## KITTITAS COUNTY COMMUNITY DEVELOPMENT SERVICES

### RE: Macham Short Plat (SP-09-00017)

The Kittitas County Community Development Services Department has determined that the Macham Short Plat (SP-09-00017) is a complete application and hereby grants *conditional preliminary approval* subject to the following conditions:

MACHAM SHORT PLAT
 PORTION OF THE NORTH 1/2 OF SEC. 28, T.20N., R.17E., W.M.
 KITTITAS COUNTY, WASHINGTON

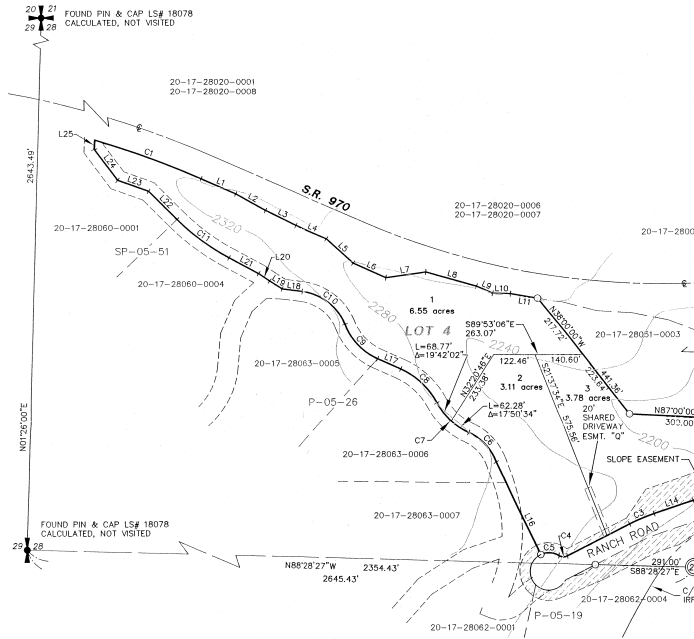
1. Both sheets of the final mylars shall reflect short plat number SP-09-00017 and an accurate legal description shall be shown on the face of the final plat.

- No direct access to SR 970 will be allowed from this plat.
  - Prospective purchasers of lots are urged to make inquiries at the Kittitas County Department of Public Works regarding road and access development requirements and permits.

10. The addresses shall be clearly visible from both directions at the County Road for all properties.
11. The Fire Department access road shall be capable of supporting 75,000 lbs in all weather, be 20' wide, provide 13'6" vertical clearance and provide for adequate turn-around for fire department apparatus.
